**KIRKLEES METROPOLITAN COUNCIL  
INVESTMENT & REGENERATION SERVICE**

**Reference No:** 2017/62/93470/E

**Site Address:** adj, 93, Stocks Bank Road, Mirfield, WF14 9QB

**Description:** Demolition of existing garage erection of detached dwelling with integral garage and associated site works

Stocks Bank Rd (30)001 /
Proposed Elevations

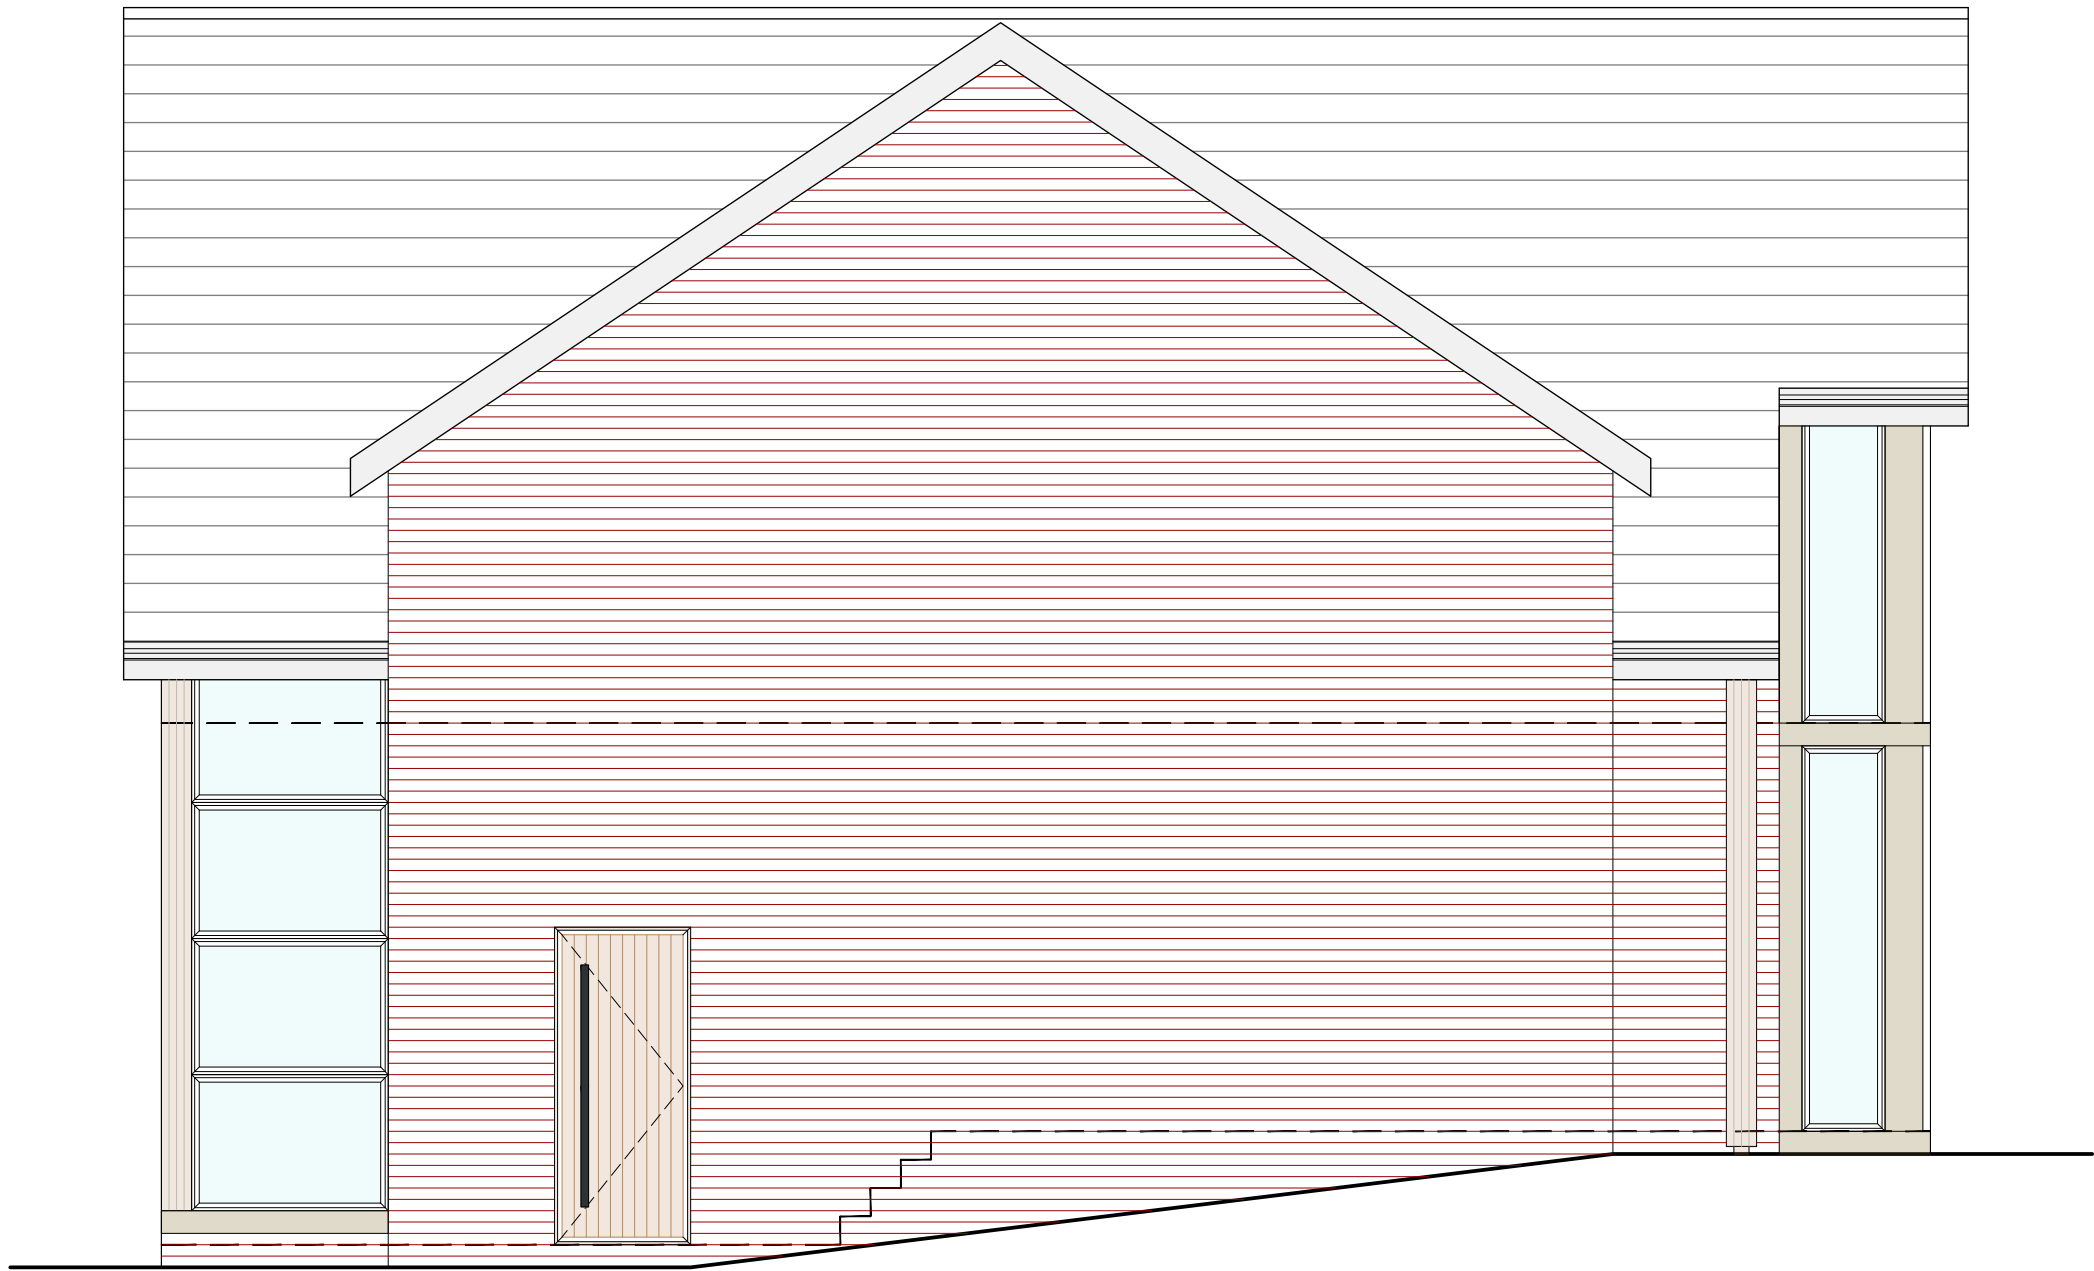
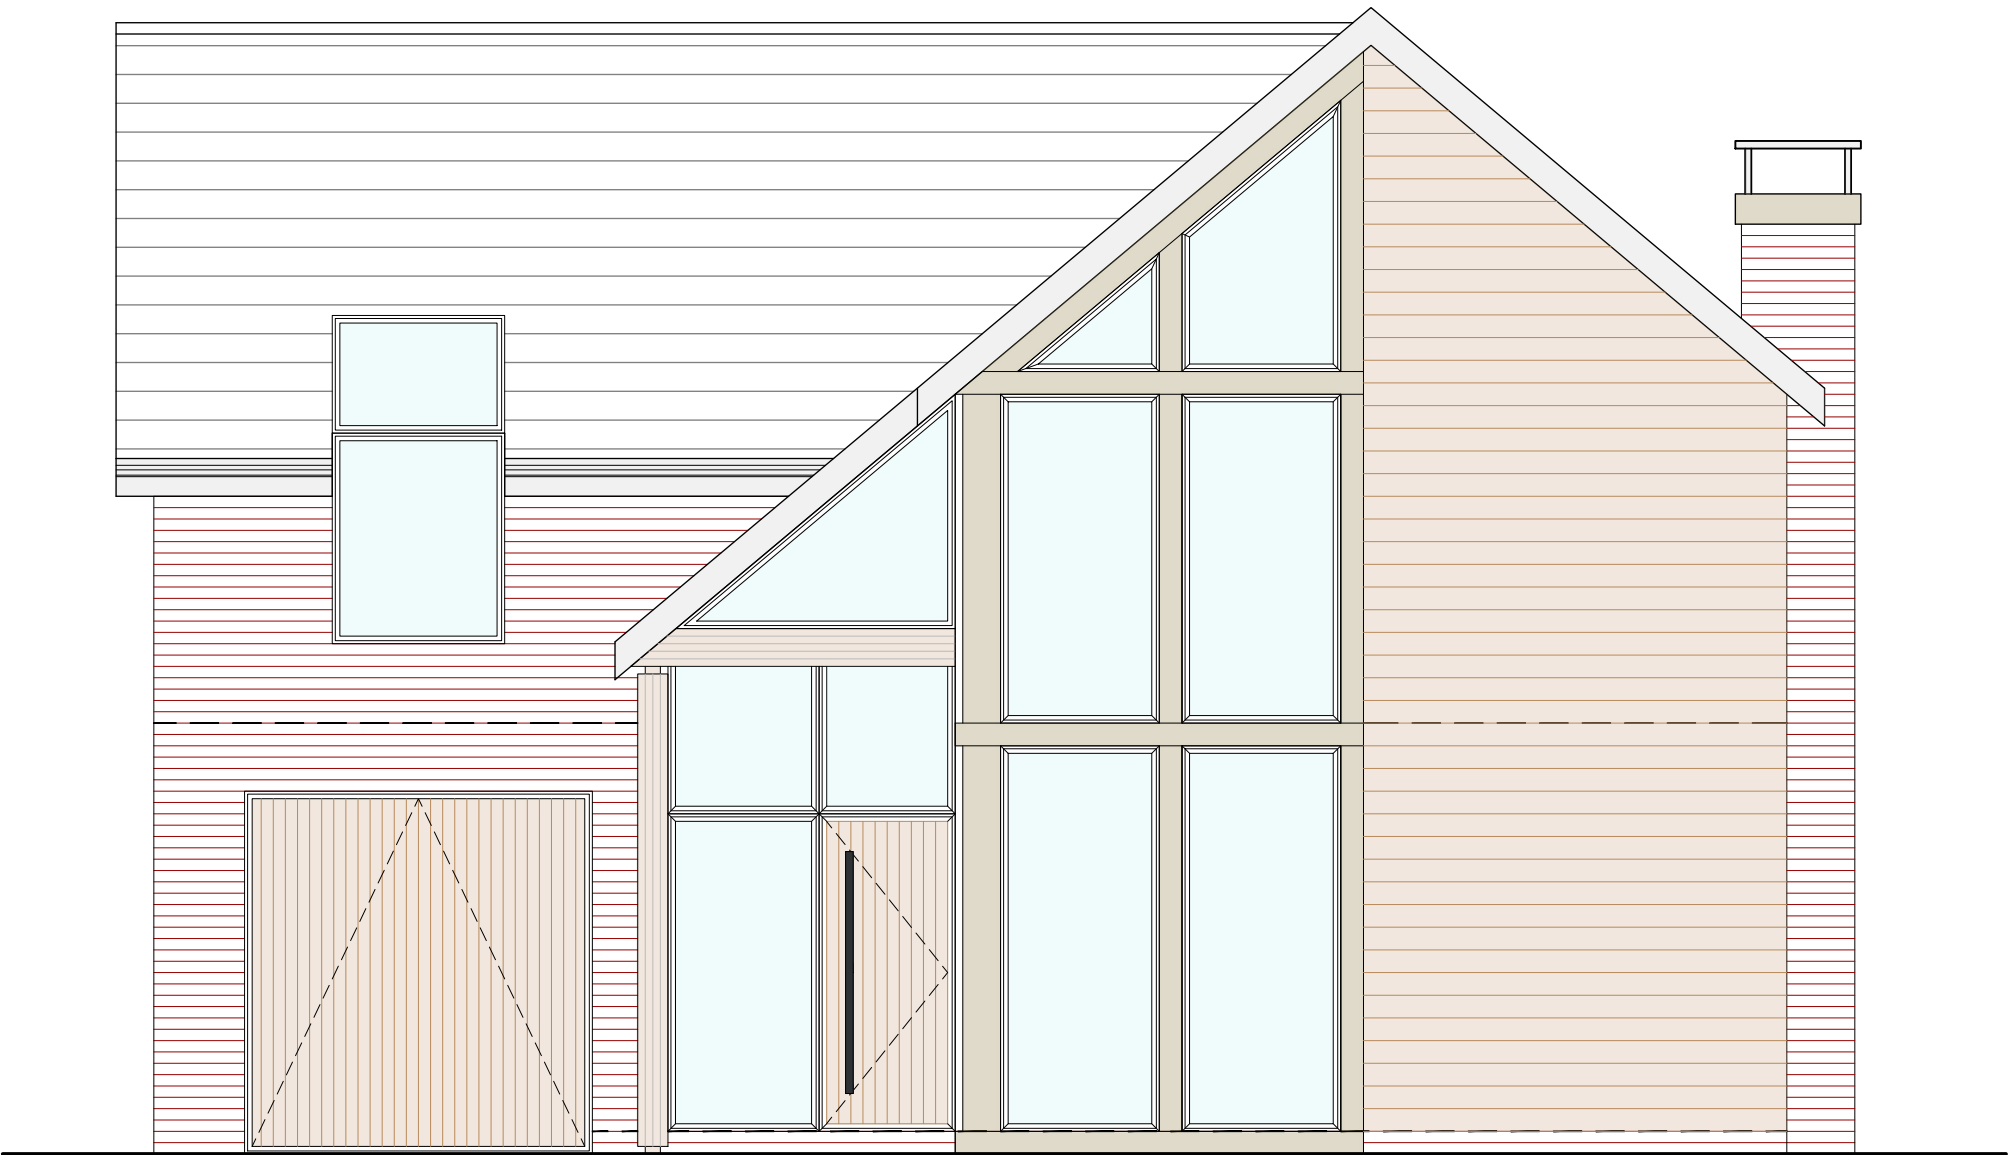
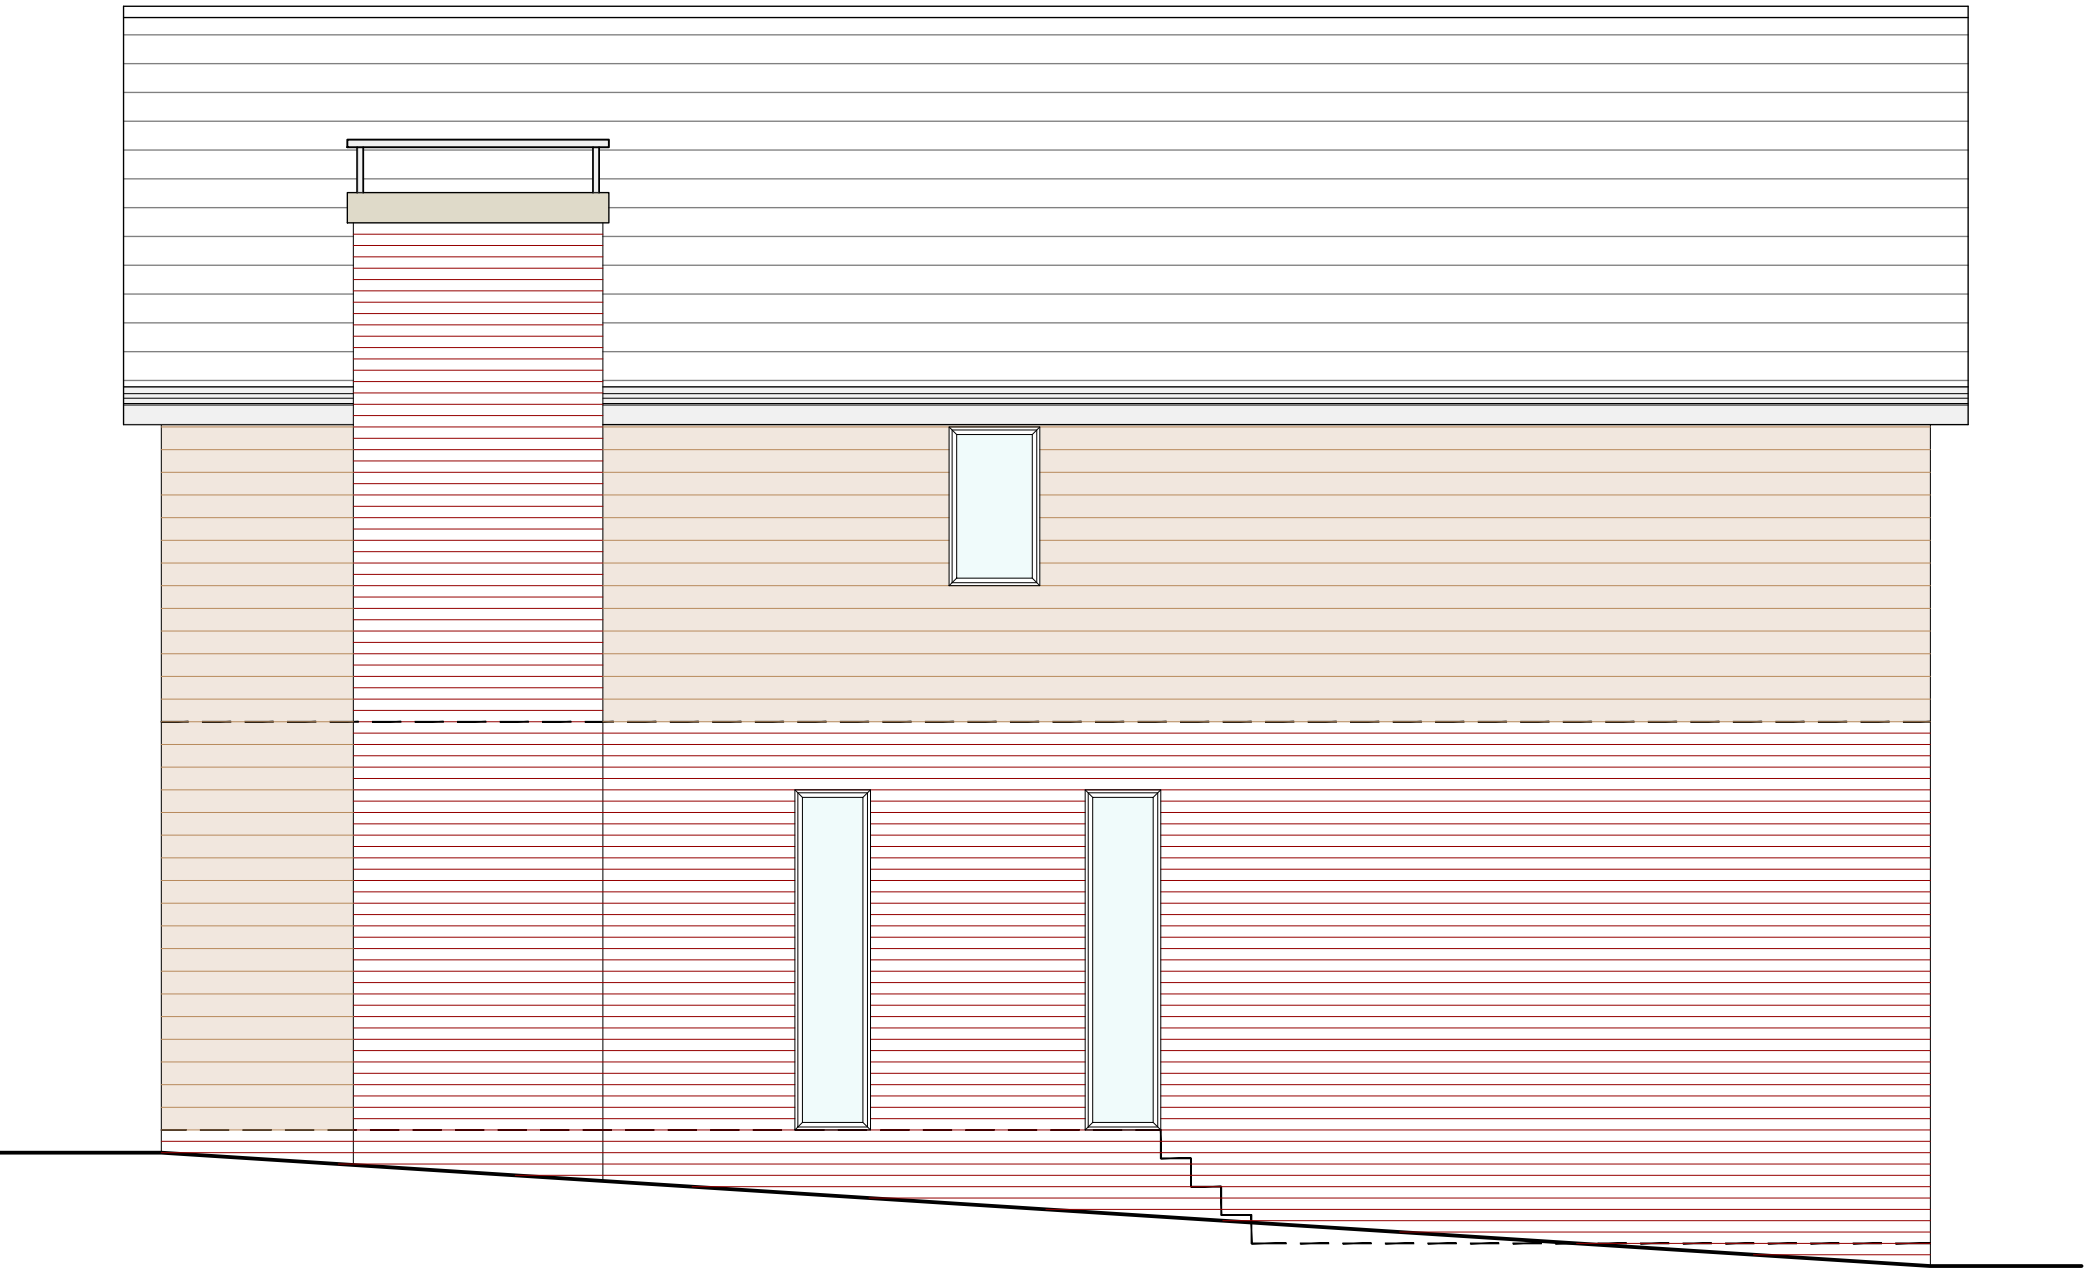
1. The proposed dwelling, by virtue of its scale and proximity to surrounding dwellings, would result in the overdevelopment of the site which would have a detrimental overbearing impact upon the residential amenity of the occupants of the surrounding dwellings, contrary to Policies D2 and BE12 of the Kirklees Unitary Development Plan as well as Policy PLP24 of the Kirklees Publication Draft Local Plan.
